DEVELOPMENT REVIEW BOARD--SPEED MEMO

DRB Application No.: 08DRB-70225	Project # 1006571
Project Name: LANDS OF GEORGE R EK	
Agent: DOUG SMITH	Phone No.: 255-5577
Your request was approved on	by the DRB with delegation of signature(s) to the DBE ADDRESSED
TRANSPORTATION:	
UTILITIES:	
CITY ENGINEER / AMAFCA:	
PARKS / CIP:	
PLANNING (Last to sign): R-2	uce refer parenet
-Tax printout from the County Assess 3 copies of the approved site County Treasurer's signature with the County Clerk.	or the County Clerk. Source. Source County Clerk). RECORDED DATE: Source. Sour

CITY OF ALBUQUERQUE PLANNING DEPARTMENT May 21, 2008 DRB Comments

RE: Tract 309-B-2, MRGCD Map #38

PLAT
OF
TRACTS A & B
LANDS OF GEORGE R. EK
(BEING A REPLAT OF TRACT 309-B-2)
M.R.G.C.D. MAP NO. 38
PROJECTED SECTION 13, TOWNSHIP 10, RANGE 2 EAST
TOWN OF ALBUQUERQUE GRANT
CITY OF ALBUQUERQUE, BERNALILLO COUNTY, NEW MEXICO
APRIL 2008

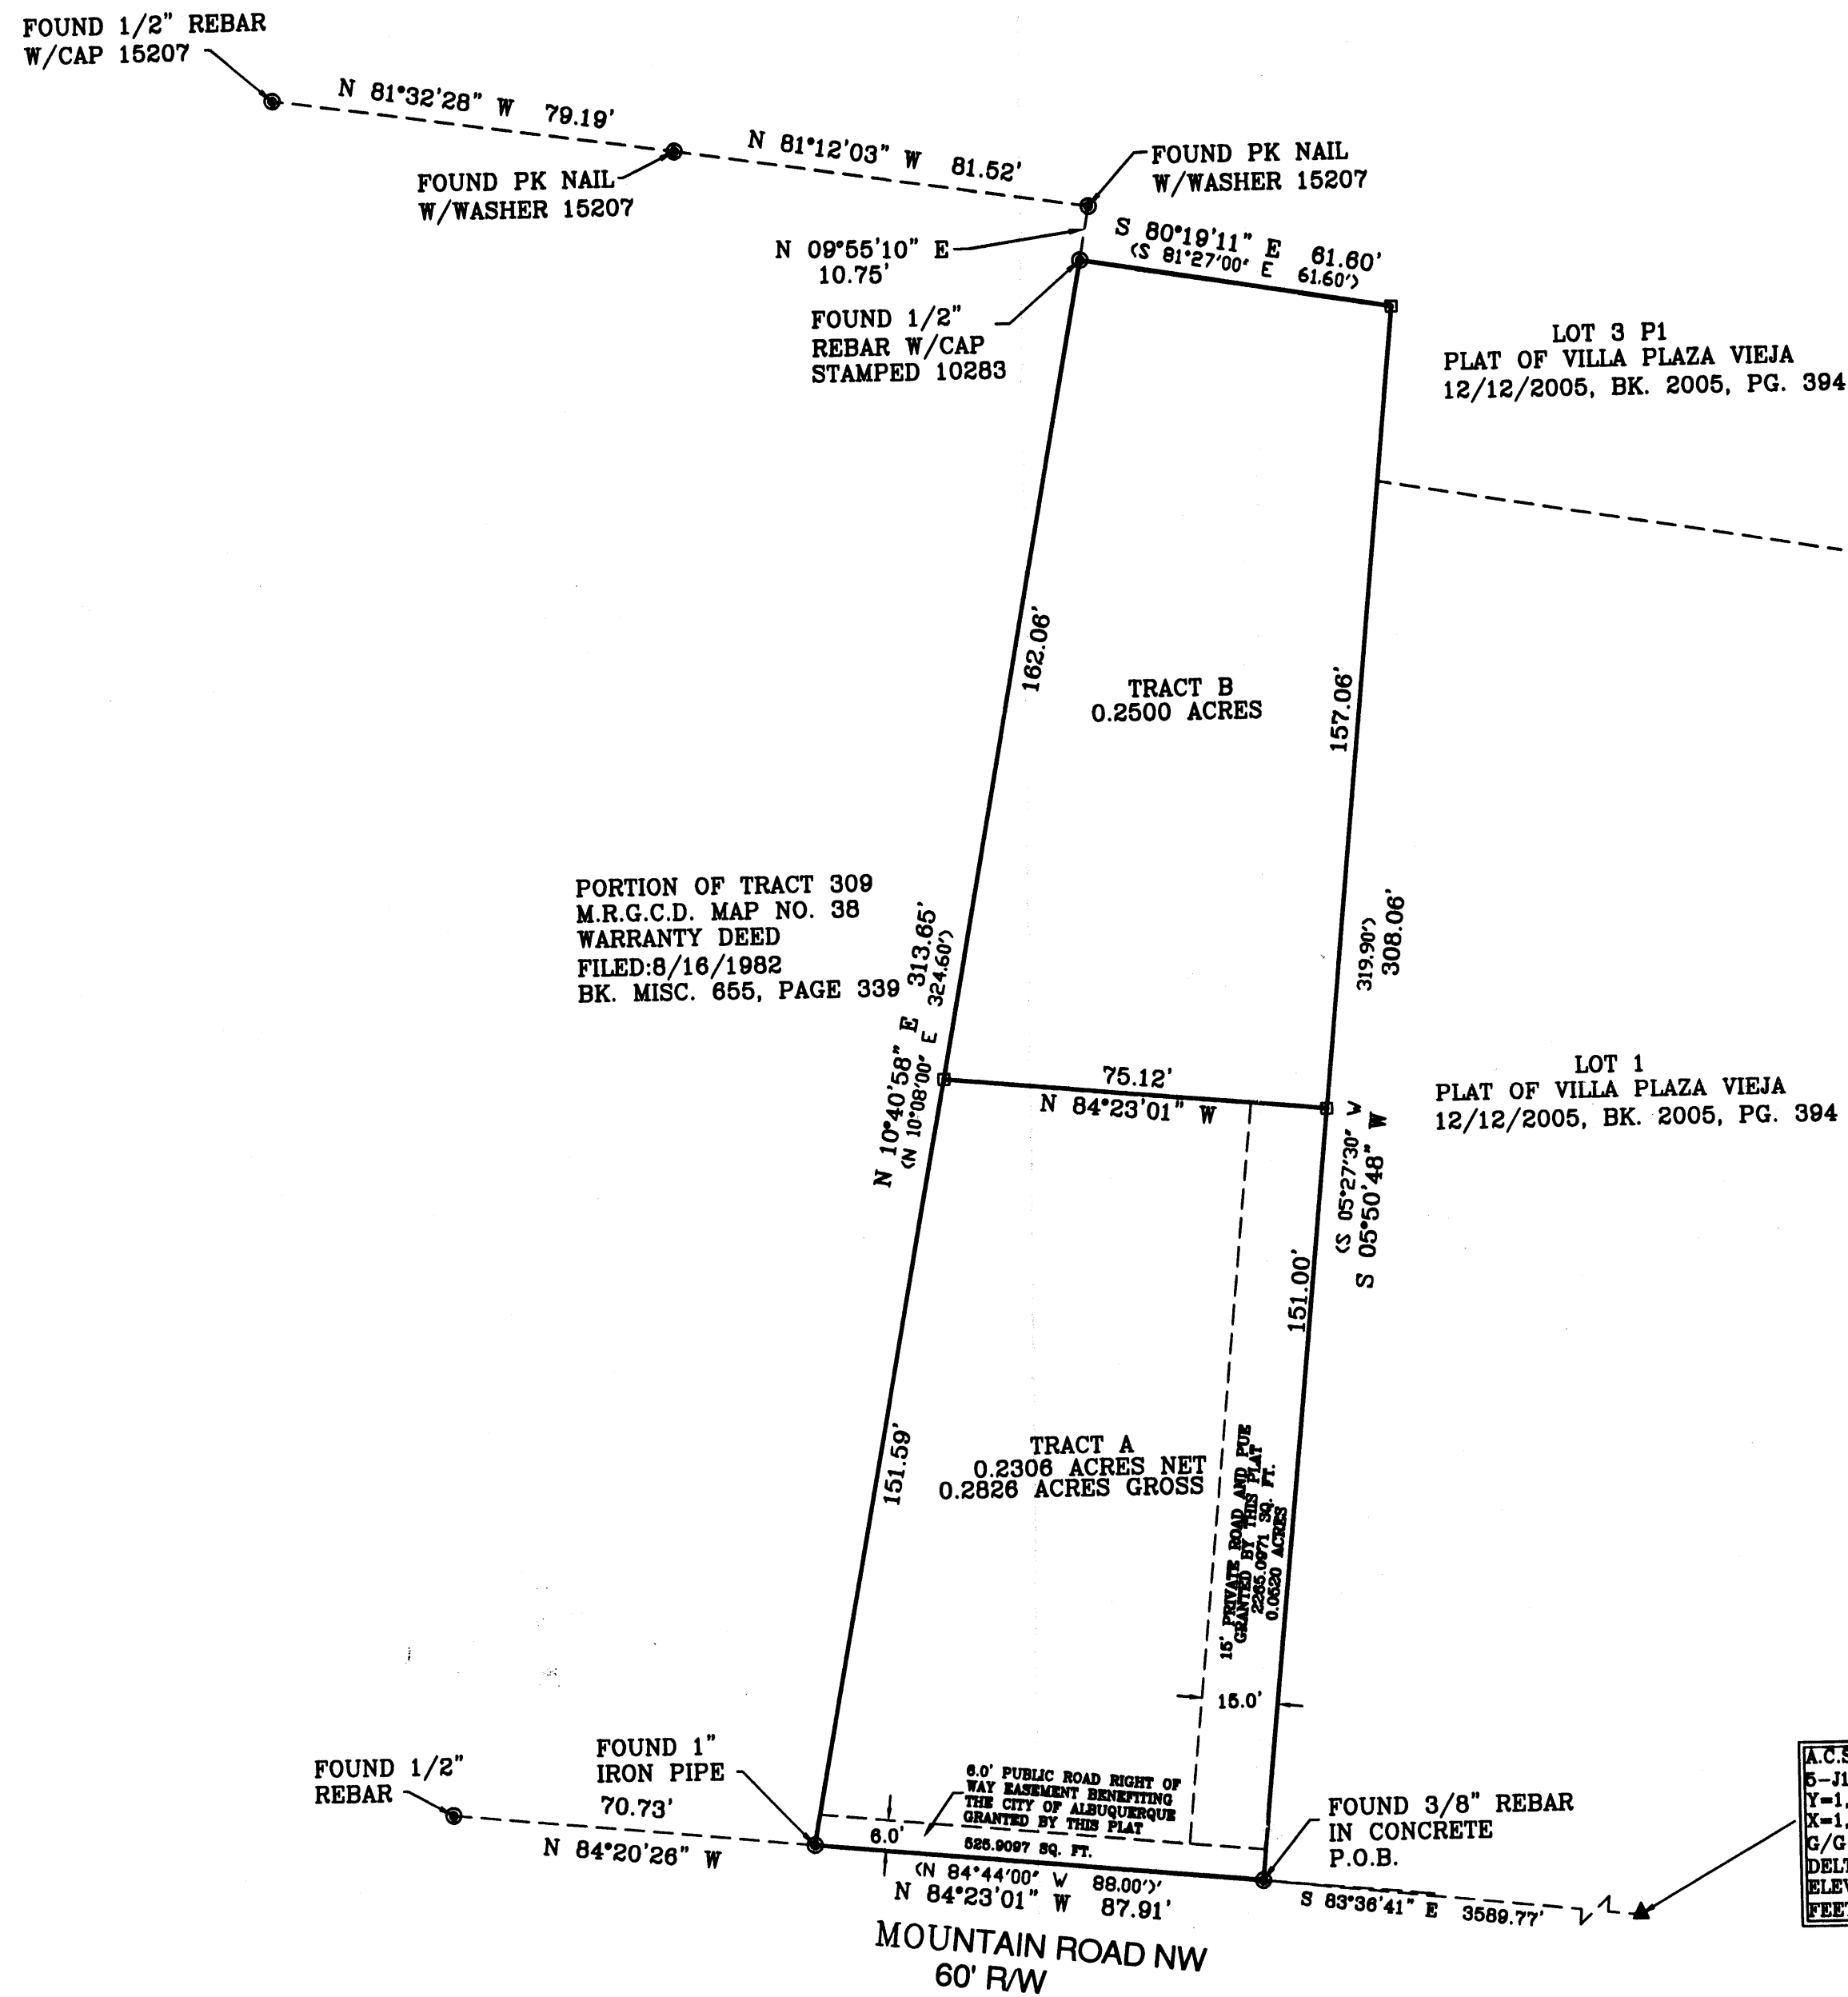
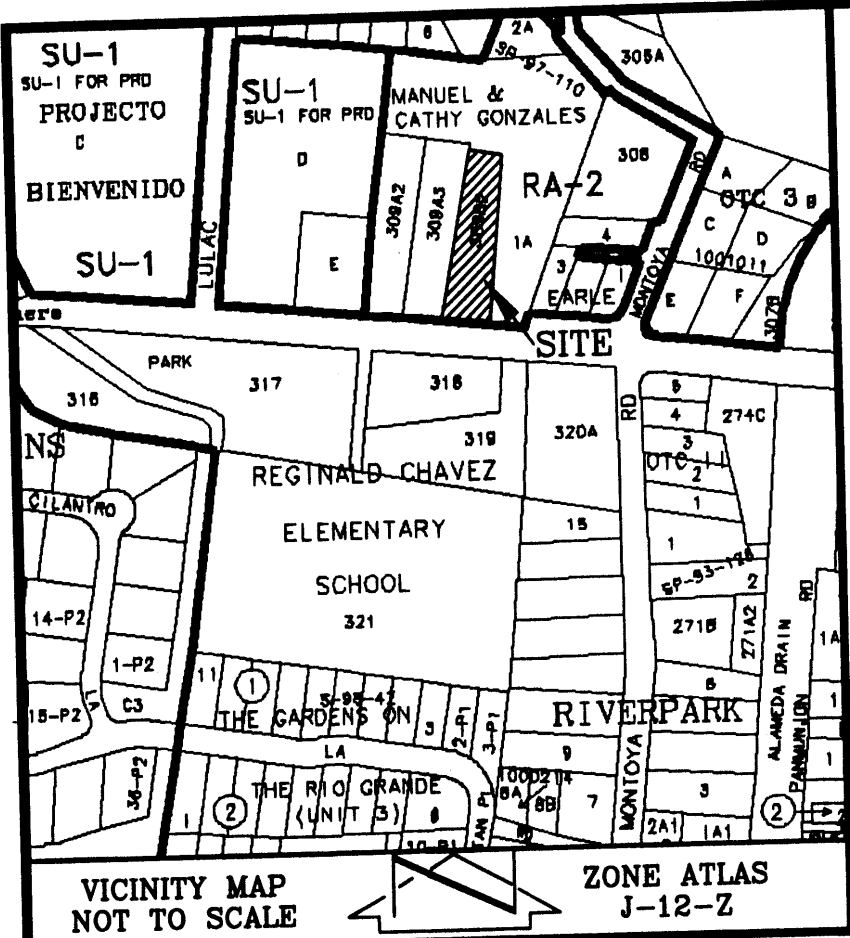
Please do not identify the property's zoning on the plat. Also, please delete the duplicate solar note (6 & 8) and revise the remaining note to be specific to this type of request, i.e. use the words "THIS PLAT" and not "REQUESTED FINAL ACTION" at the beginning of the note and delete the words "OR SITE DEVELOPMENT PLAN FOR SUBDIVISION" from the end of the note.
